Submission No.			268	
Organisation Name or Name of Submitter			Rohan Holdings Limited (represented by John Spain Associates)	
Item No.	Section Ref.	Page No.	Observation Statement	TII Response
PROPOSAL: METROLINK RAILWAY ORDER - ESTUARY THROUGH SWORDS, DUBLIN AIRPORT, BALLYMUN, GLASNEVIN AND CITY CENTRE TO CHARLEMONT, CO.DUBLIN), ABP REFERENCE: NA29N.314724				
1	Grounds of Submission (paragraph 1 and 2)	2	Due to the delays in bringing forward the route and plan for delivery of the previous Metro North proposals and the current MetroLink proposals, our client's lands have been sterilised for the past 15 years. Despite our client's previous submissions highlighting the impact of the project on the strip of land fronting onto the R132, our client is concerned that the balance of the lands have now been identified for temporary land take for the provision of construction compounds (See Figure 3) thus further sterilising the lands from development until MetroLink is delivered as opposed to identifying less valuable lands for such purpose	TII are only occupying lands necessary for the delivery of MetroLink.

Drawing Title	METROLINK - GENERAL ARRANGEMENT SEATOWN (SHEET 1 OF 3)		Drawing Status	S1
Drawing N°	ML1-JAI-ARD-ROUT_XX-DR-Y-03012	Plan Drawing N°	ML-RO 301 H-J	
Scales Original Size A1	AS SHOWN	Sheet	1	of 1

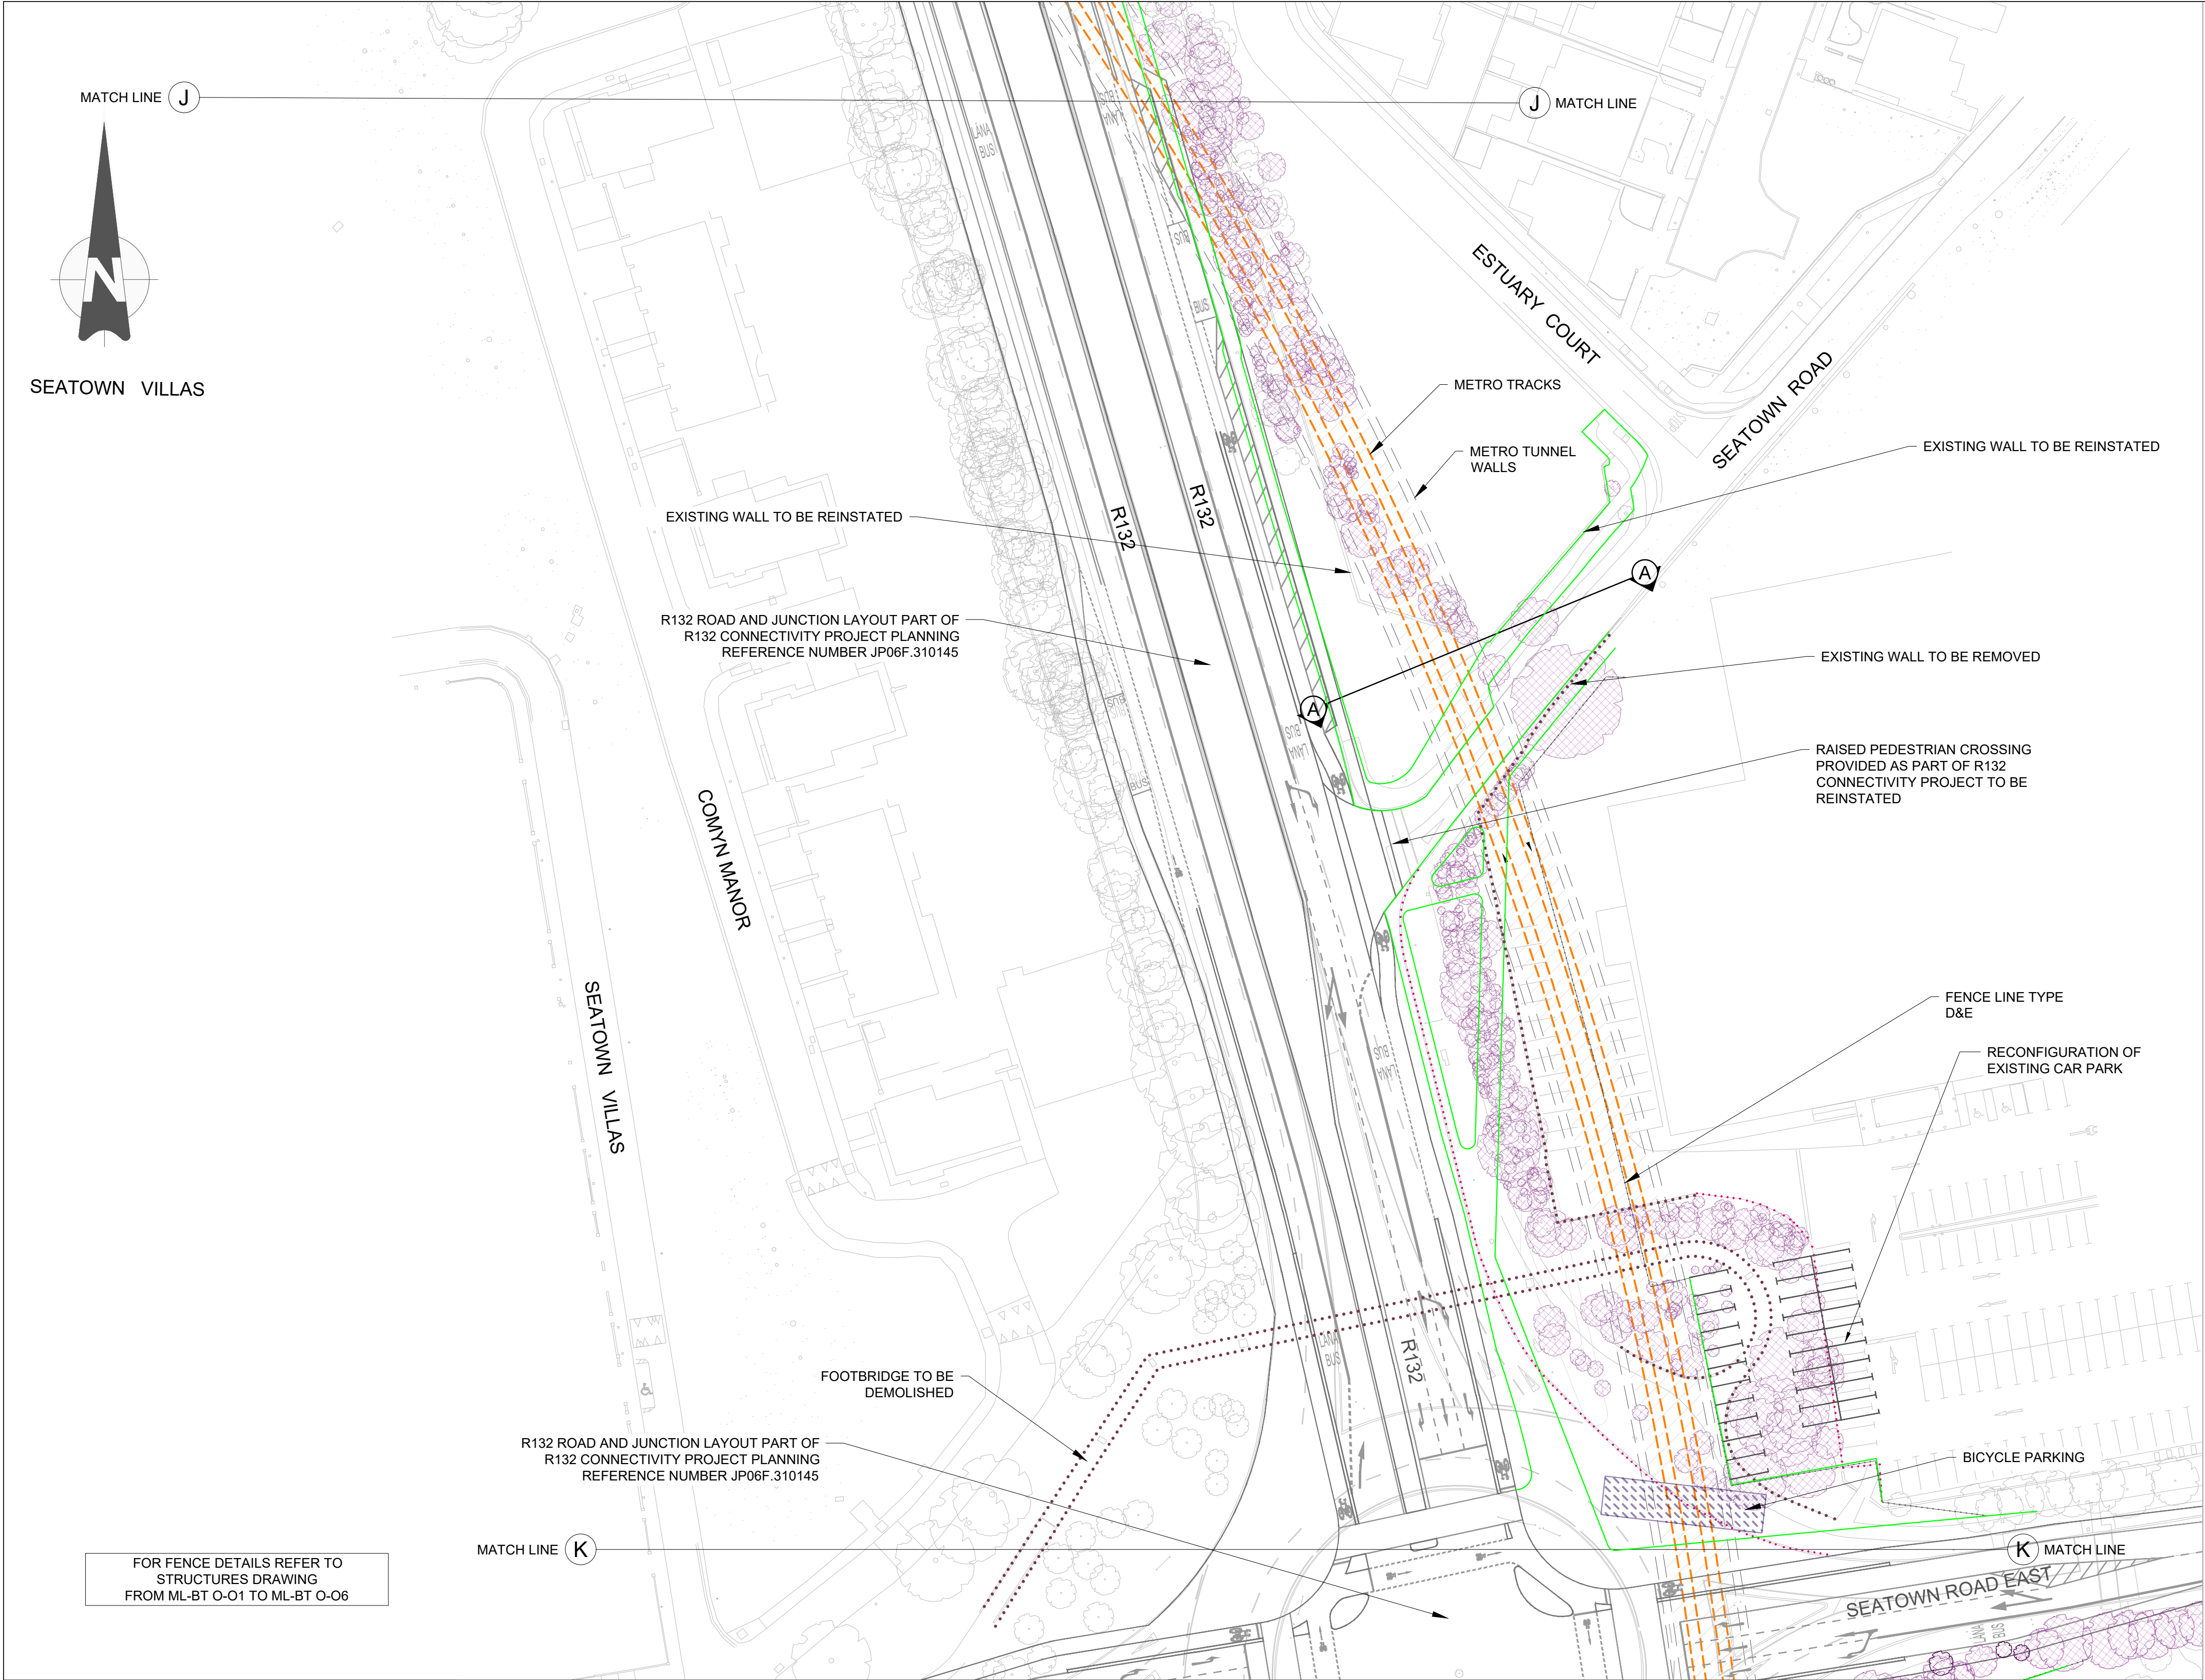
2	Grounds of Submission (paragraph 3)	2	The construction compound figures as per the extract below (and included in Chapter 5 of the EIAR) illustrate it is proposed the lands will form part of the proposed main and satellite construction compounds for the Seatown Station. Chapter 21 of the EIAR states that the temporary land will be utilised for a period of time to facilitate the construction of the proposed project, but is then returned to its former use. However there are no timescales provided on when the additional lands required for the temporary compounds will be returned.	The overall programme of works is shown in EIAR Appendix A5.2. The detail underpinning this will be confirmed once the main works contractor's programmes have been received. TII will work with the appointed contractors to optimise any land take requirements and reduce the duration of use, currently estimated to be 6 years. The final extent of land take and duration of use will be confirmed by the appointed contractor.
